Subject: Response To Application Number BR/96/19/DOC at 3 Glencathara Road Bognor Regis PO21 2SF

TO:	Arun District Council FAO: Mr S Davis
FROM:	WSCC - Highways Authority
DATE:	25 April 2019
LOCATION:	3 Glencathara Road Bognor Regis PO21 2SF
SUBJECT:	BR/96/19/DOC Approval of details reserved by condition imposed under ref BR/32/16/PL relating to Condition No. 4 storage of waste and No. 5 vehicular access.
DATE OF SITE VISIT:	
RECOMMENDATION:	Advice
S106 CONTRIBUTION TOTAL:	£ N/A

Condition 5 – Vehicular Access

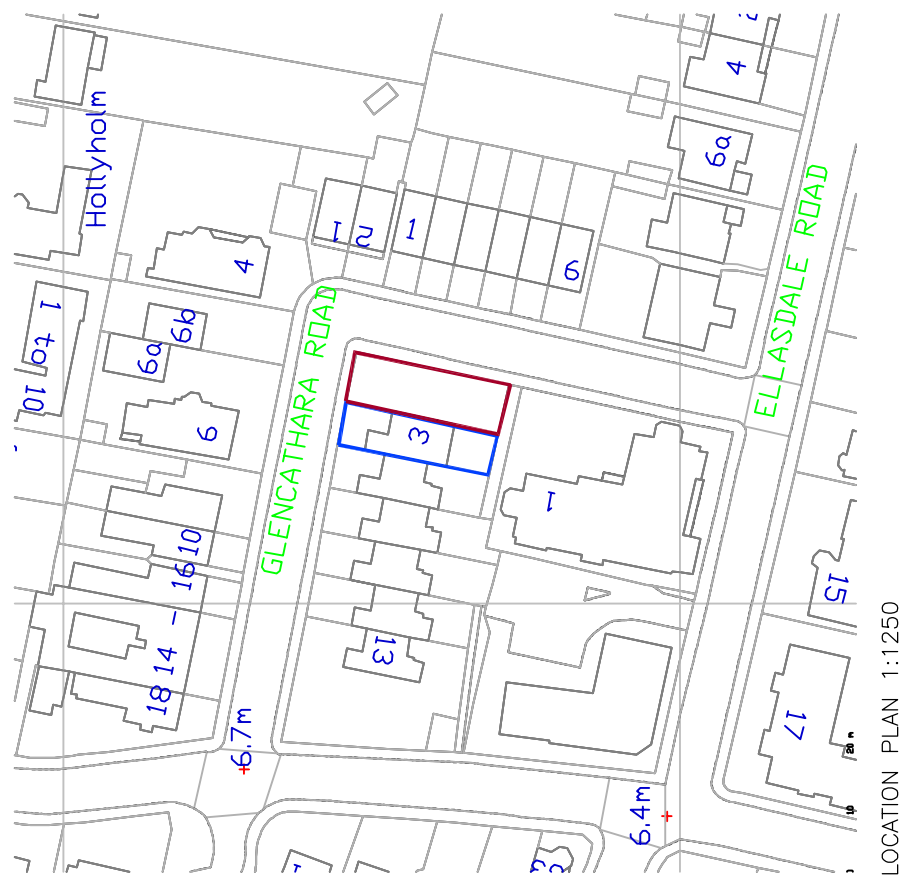
I note that there have been no details submitted outlining the height of the wall/boundary treatment either side of the access which would be beneficial at this time, this information will be required at a later date to discharge the pedestrian visibility condition regardless.

I note that the western side pedestrian visibility splay may lie outside of the ownership of the applicant therefore I advise for 2m back into the site that no walls, fences or planting should be installed exceeding 0.6m within their red edge. Similarly the wall/fence/ planting on the eastern side of the access must be demonstrated as not exceeding 0.6m in height for 2m also.

The applicant has provided details outlining that the VCO has been constructed, however technical sign off of the VCO will need to be obtained from the Arun Area Officer whom issued the license for the construction. The applicant has re-submitted the plan shown initially at the planning phase to show the access arrangement; the principle of access at this position on the highway is considered acceptable.
